Application for a non-material amendment following a grant of planning permission. Town and Country Planning Act 1990

MEZEN CLOSE

8. Non-Material Amendment(s) Sought

REPLACEMENT OF EXISTING TIMBER CLADDING AT
FIRST FLOOR LEVEL (EXTERNAL) WALL SURFACE WITH
WATER PROOF RENDERING; PAINTED WITH WEATHER PROOF
MASONRY PAINT. COLOUR TO BE CHOSEN

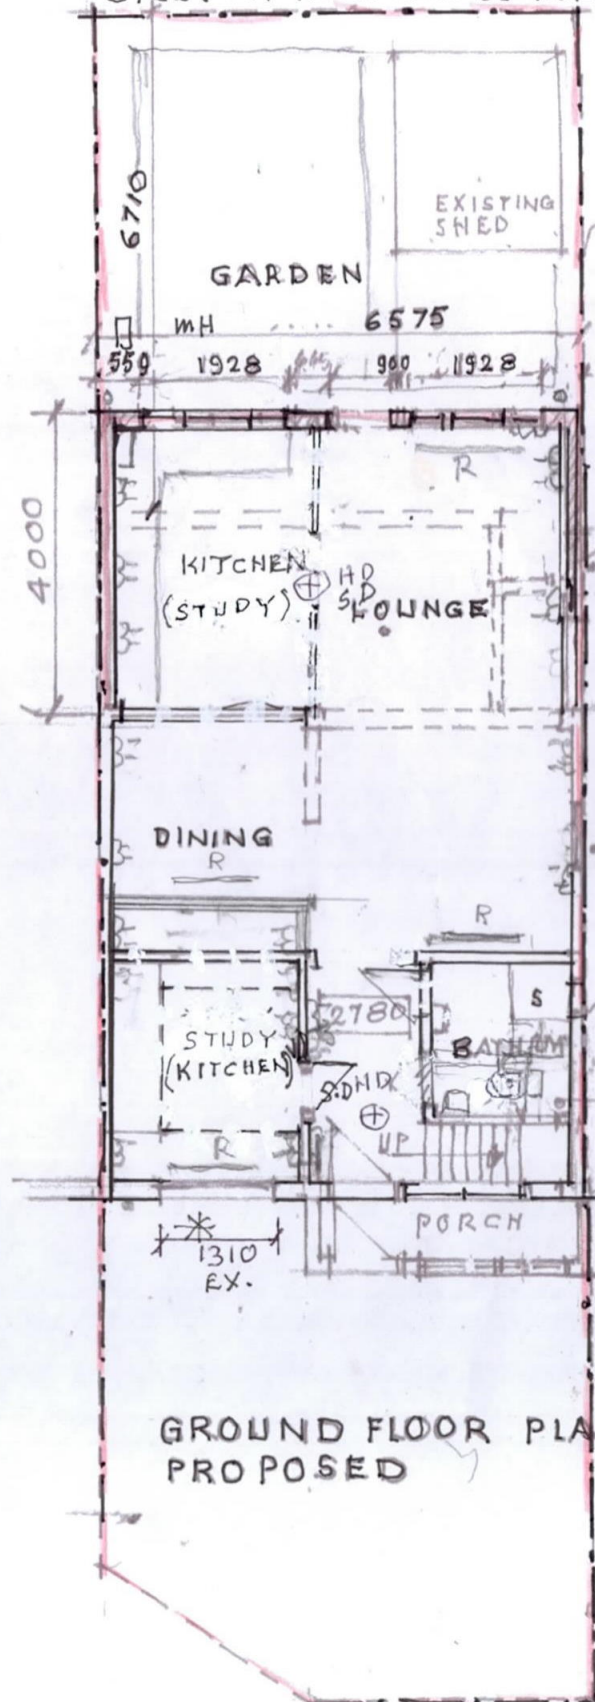
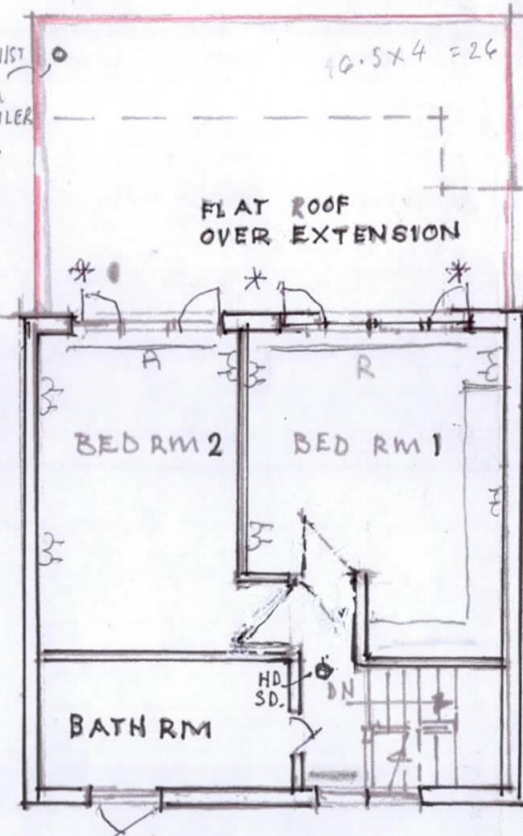
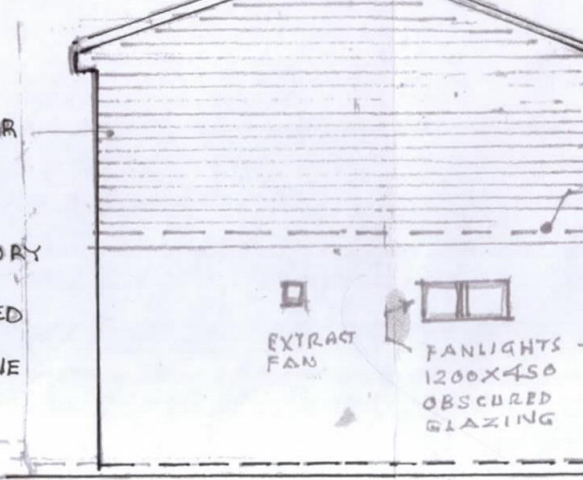
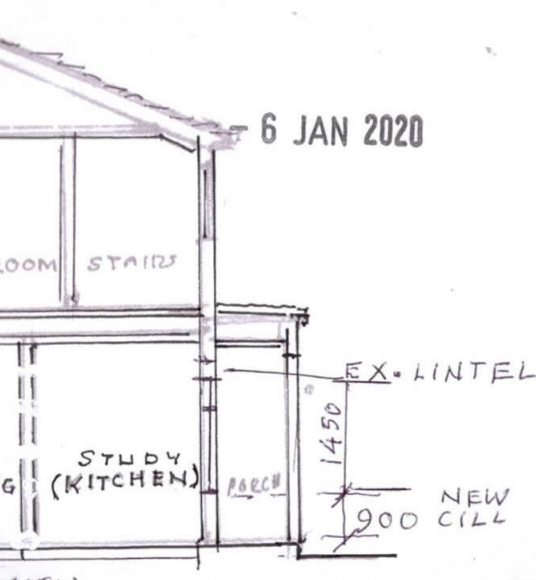
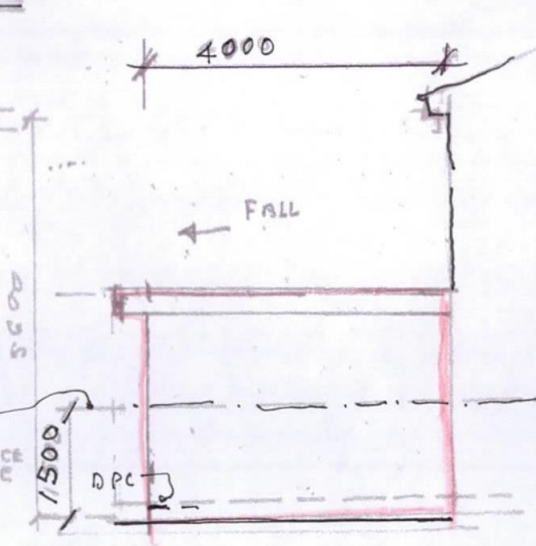
EXISTING CLADDING IS DETERIORATING & NEEDS REPLACING WITH NEW.
THE RENDERING WILL BE LONG TERM SOLUTION.
